## BHS Responses 3<sup>rd</sup> Deadline MYG

Public Rights of Way and Turbine Buffers

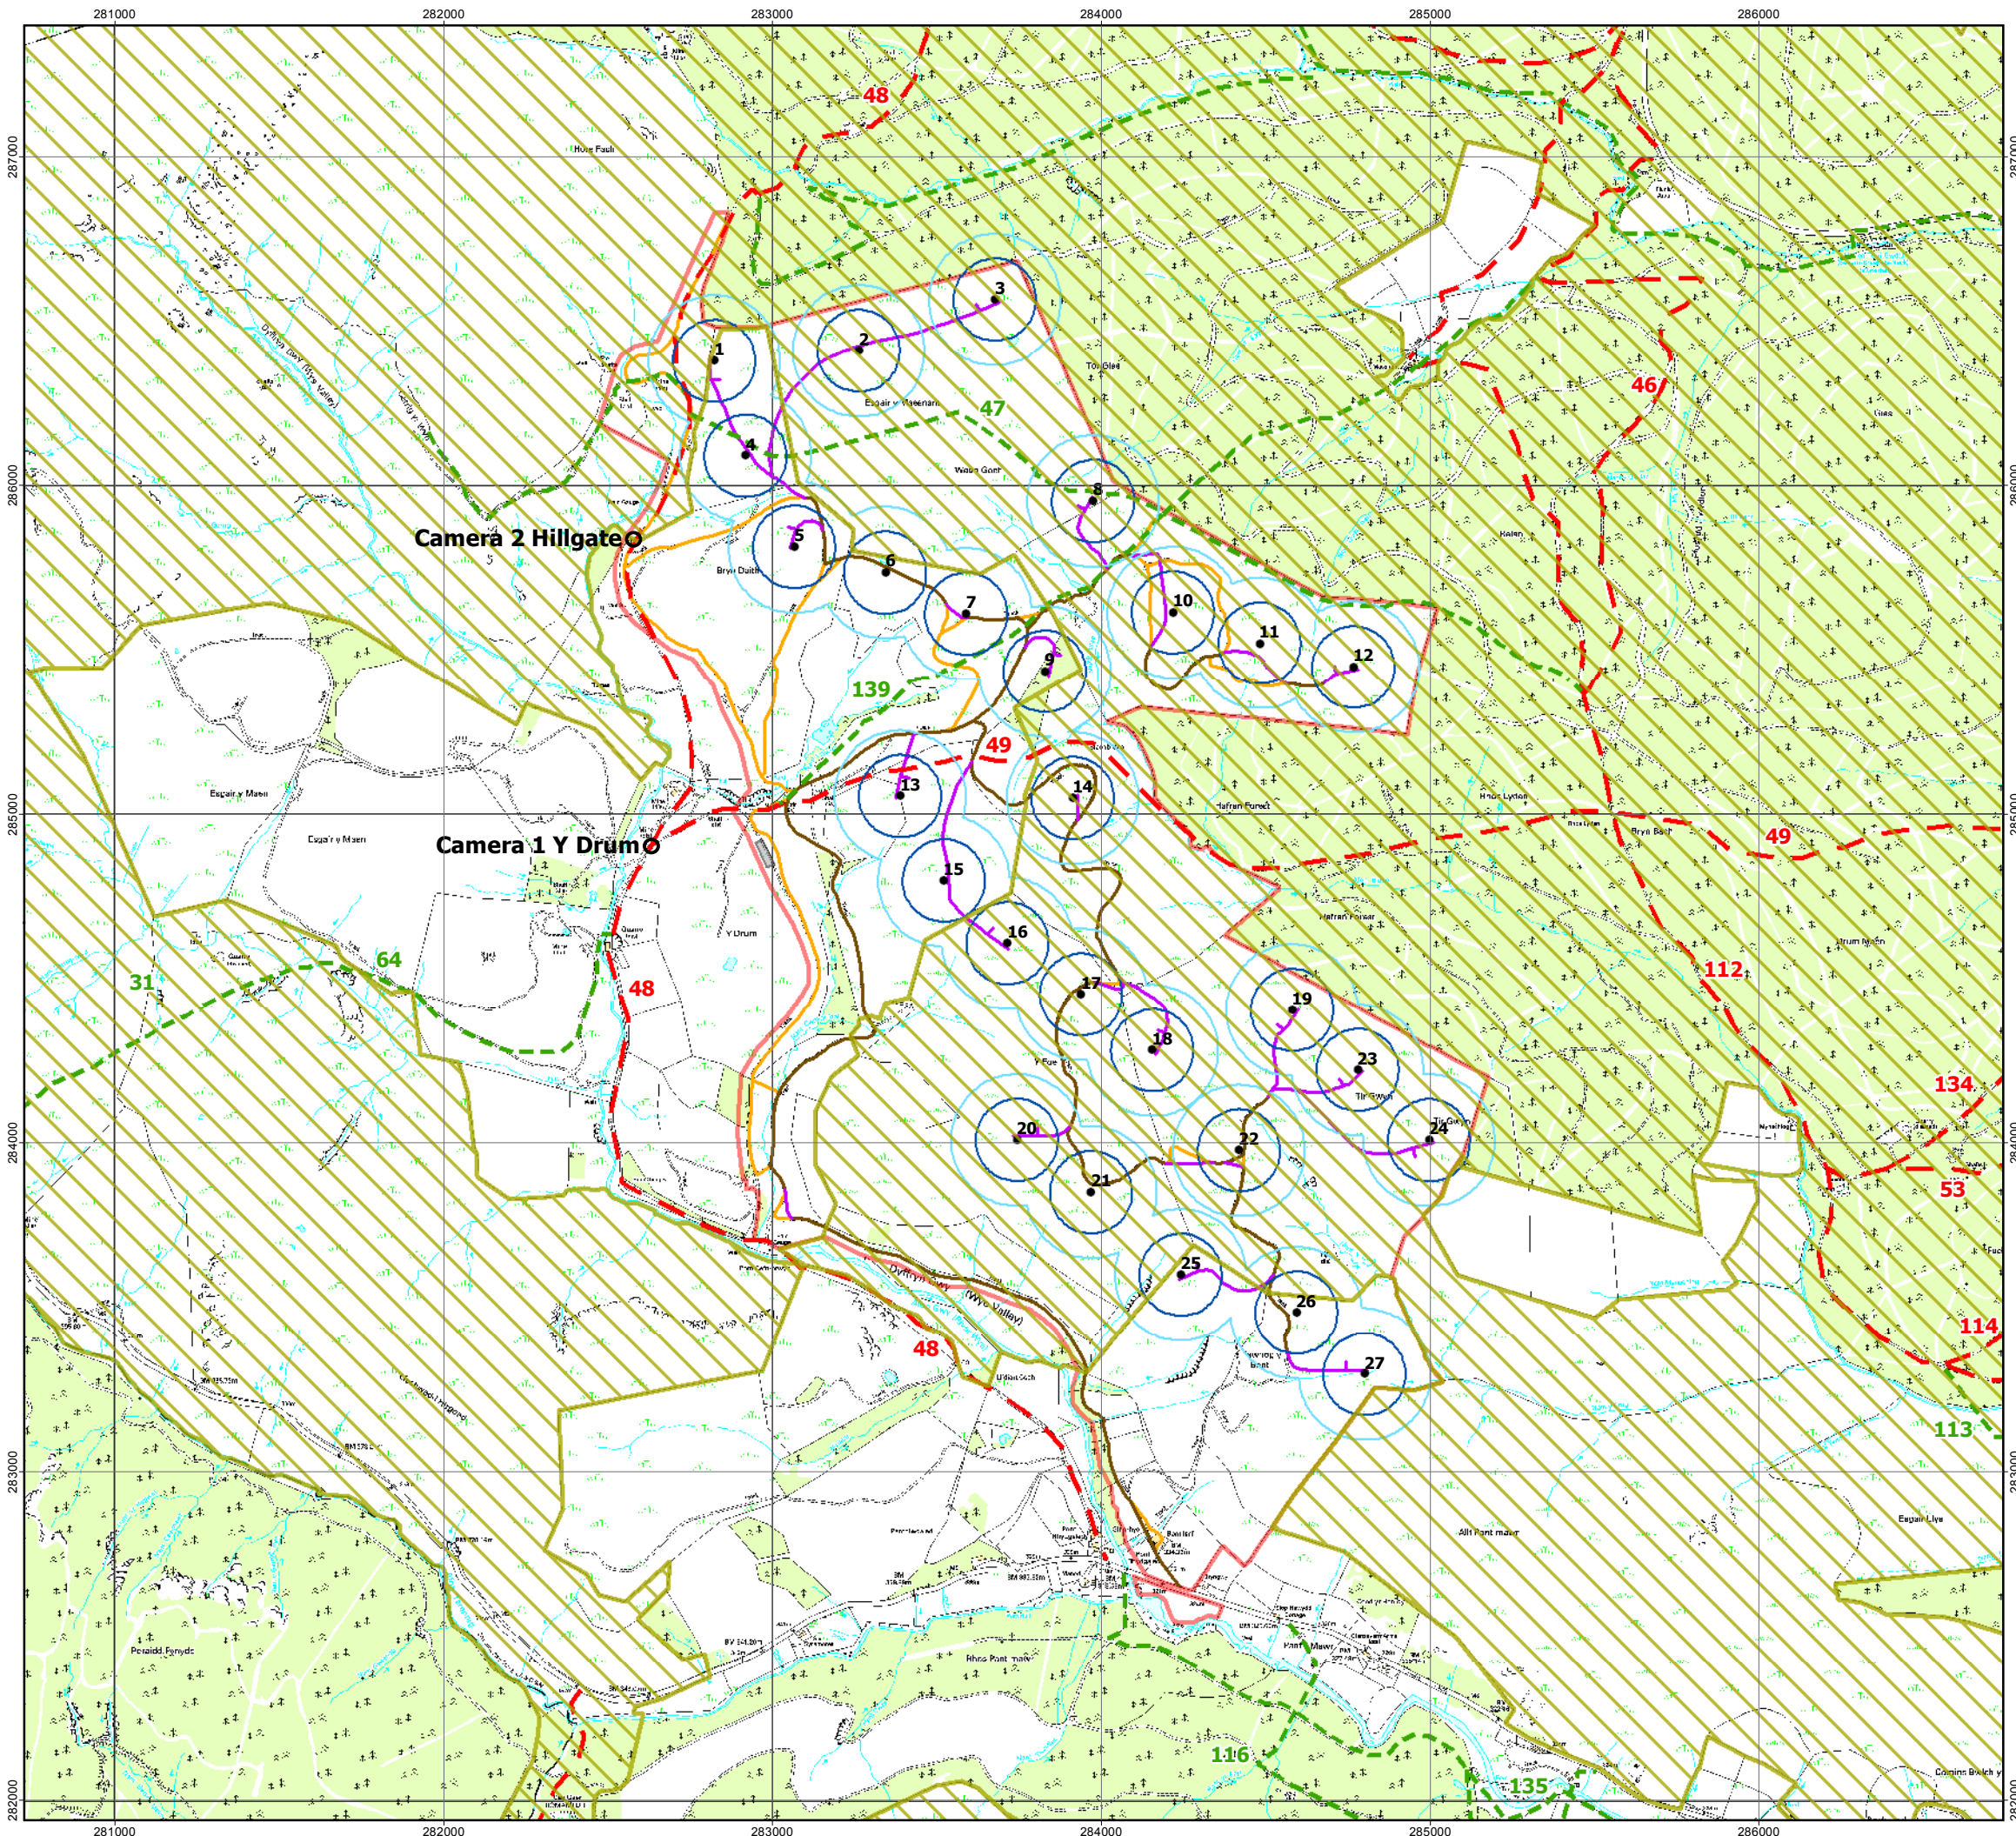
At no point does the applicant consider the needs of PRoW users, in one instance placing a turbine at 10m from a footpath, but take the line that this is what we need and this is what we will have. Anything getting in the way of that is wrong be it SSA or TAN8 guidance.
